Application for removal or variation of a condition following grant of
planning permission. Town and Country Planning Act 1990.
Planning (Listed Buildings and Conservation Areas) Act 1990

Alterations and Extensions to an existing food factory to include a two storey 'DAF' processing plant extension to the south elevation incorporating an air-lock to an existing loading bay; a separate double height extension to south elevation for a new air-lock and storage bay to an existing high bay loading dock; an internal first floor extension to create a new plant room above the existing plant room; a new internal enclosure to form a new boiler room with a new external flue; external site alterations to provide 8 extra car visitor spaces and an extra space in the access road; new vehicle double barriers; security fencing; smoking and cycle shelters; a new concrete plinth extension to the existing west side plant area for new water storage tanks, an HV Transformer in a secure compound and a balance tank and a sludge tank within a concrete bunded area, an underground waste holding tank with screening building above and associated alterations to landscaping

Reference number	51458/APP/2018/2791

Proposed Ground Floor Plan

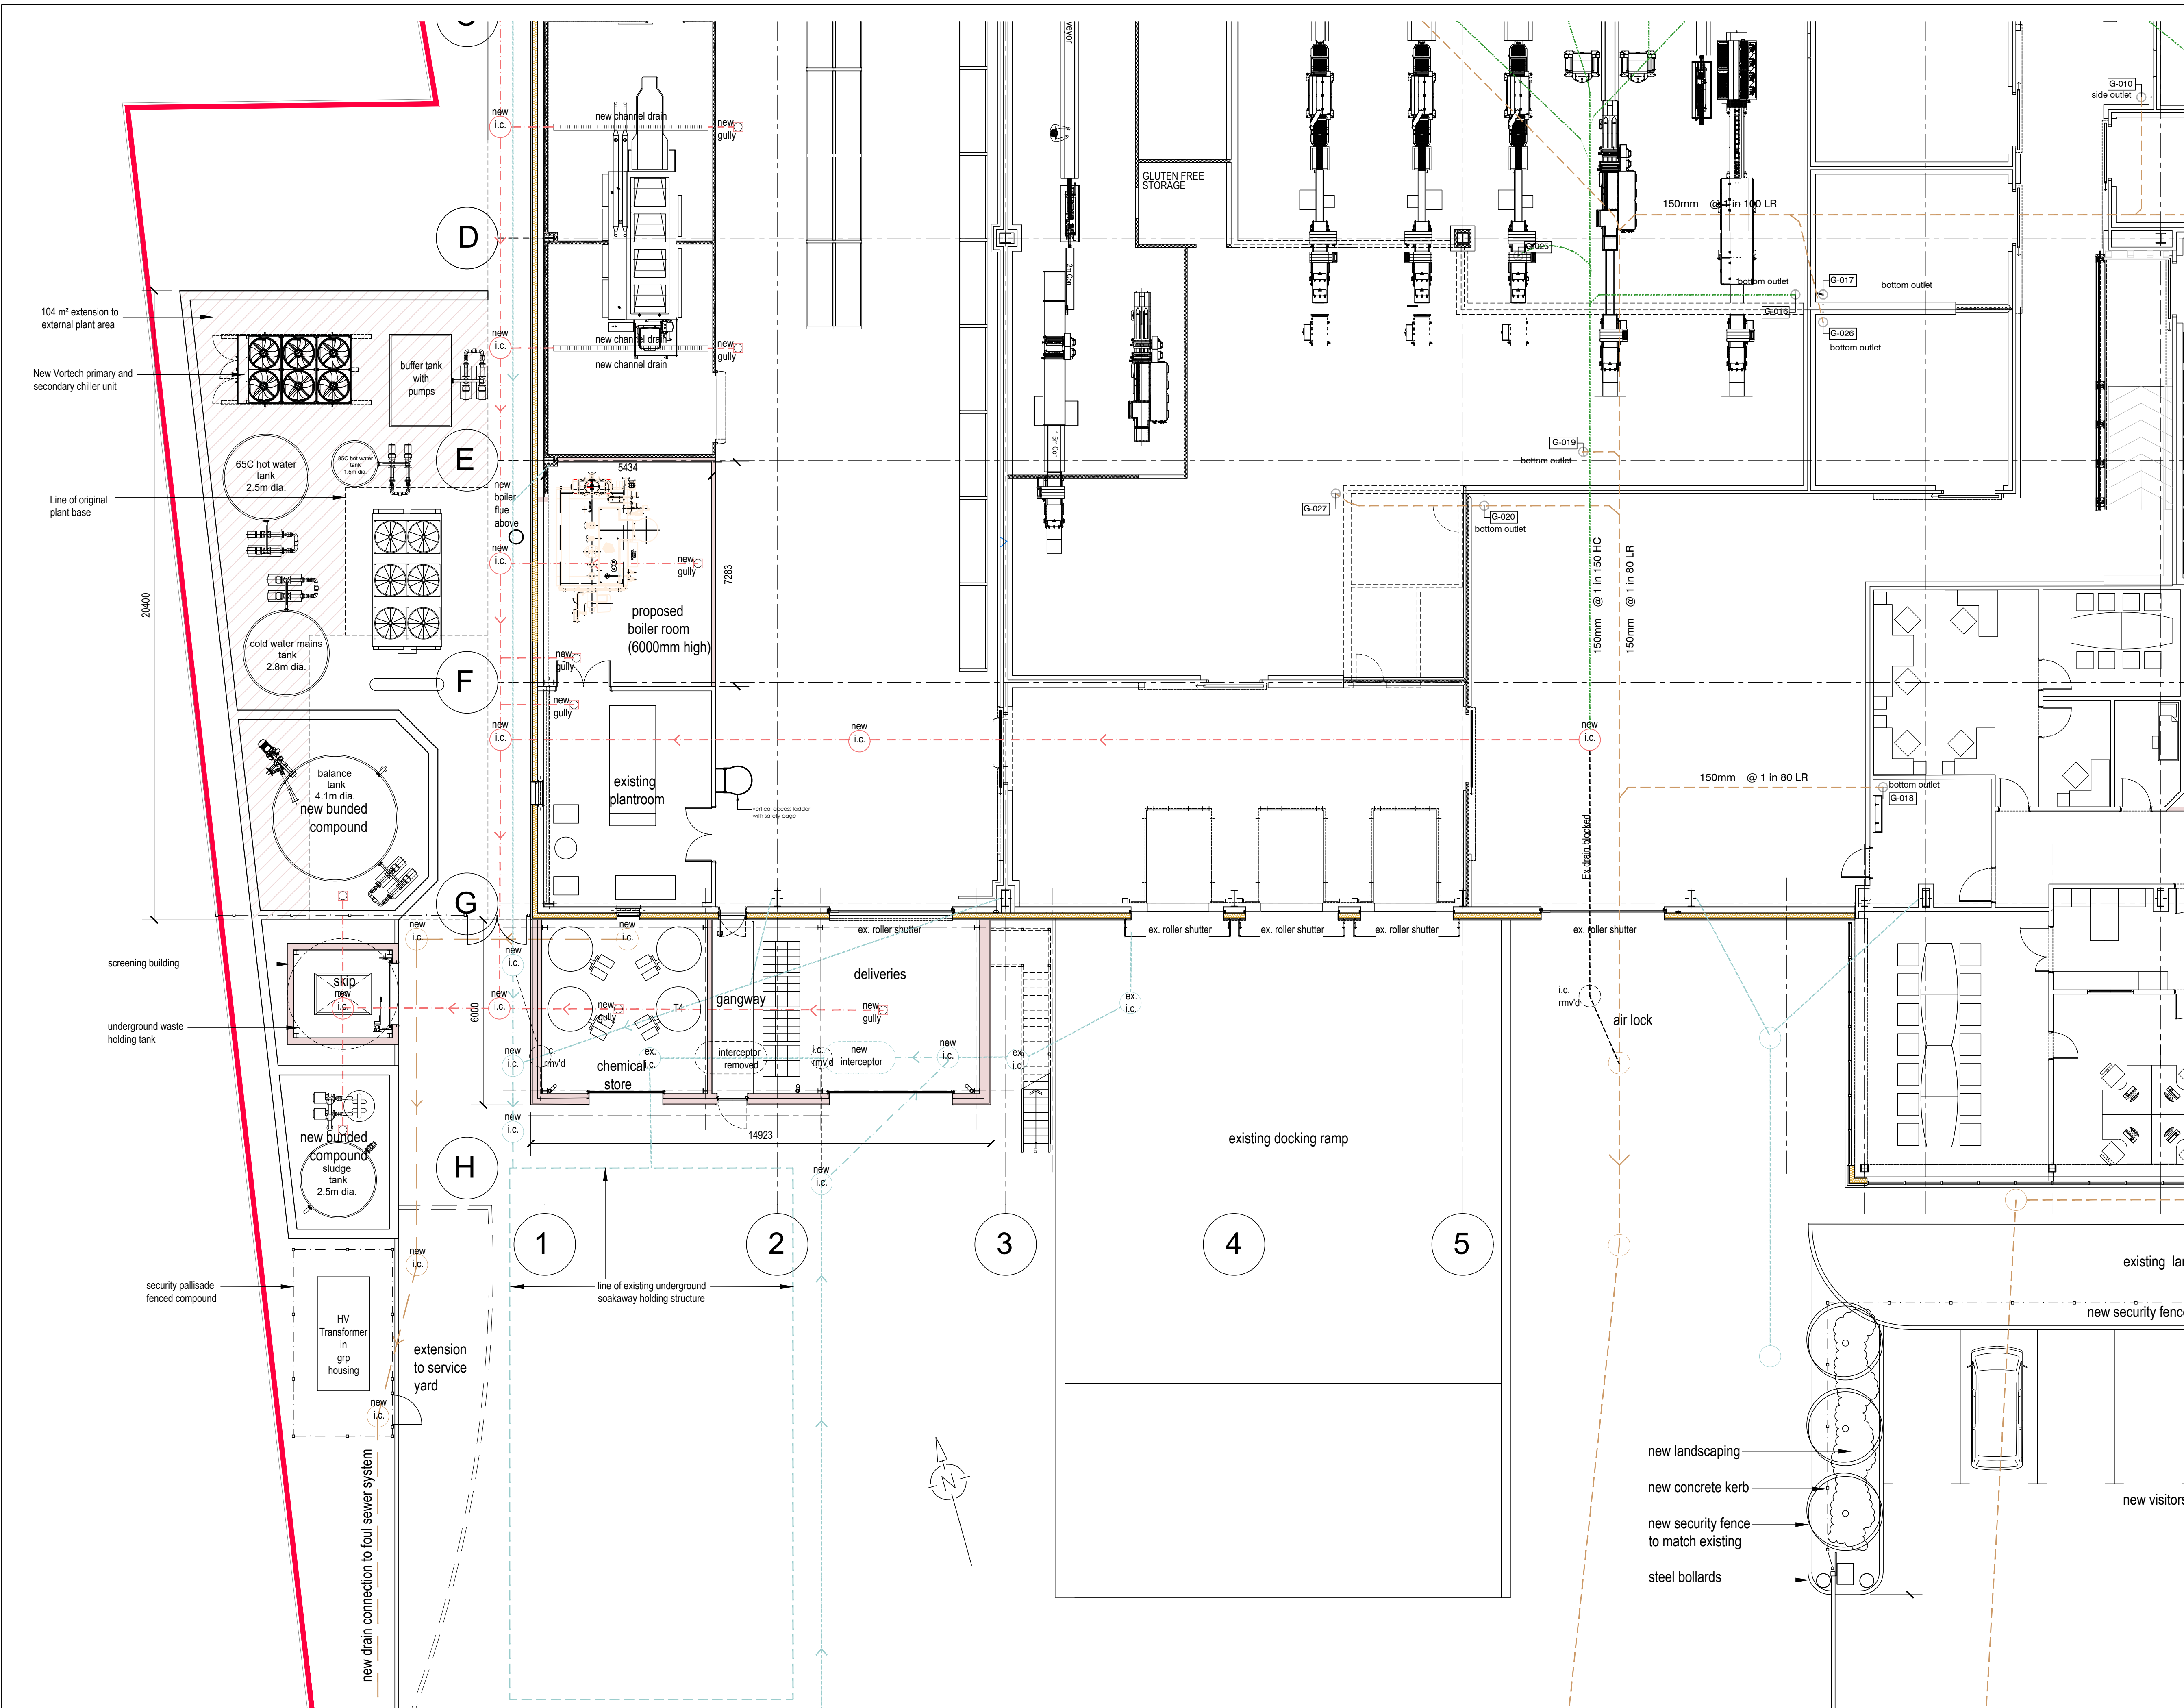
- 1) The two storey 'DAF Plant' building has been built smaller in both horizontal dimensions than the planning approved layout. The width has been reduced from 17276mm to 14923mm (-2353mm) because the existing structure to the loading bay retaining wall is not suitable to build adjacent therefore a reasonable gap needs to be maintained. The depth has had to be reduced from 6748mm to 6000mm (-748mm) because when the foundations were dug out it was found that the existing surface water soakaway structure was closer to the building than recorded on the original 'as-built' drawings therefore the depth was shortened to miss this structure.

- 2). As a result of reducing the width, the fire escape/access staircase for the first floor that was proposed to be inside the new building had to be built externally, this was not an issue for the users as access to this floor is required only occasional for short periods for engineering maintenance, no one would be working full-time in this area.

- 3). The Applicant will not build the separate 'Air-Lock' Building as this has been superseded by a new Planning Approval for a single storey extension to the existing cold store - Planning Approval No. 51458/APP/2019/2056 dated 20th. August 2019. (building work on this has not started to-date.)

To accept the smaller DAF Building, the external fire escape staircase and the deletion of the Air-Lock Building as minor amendments to the approved scheme. The Planning Condition 2 would need to replace the original drawings with the revised drawings attached.
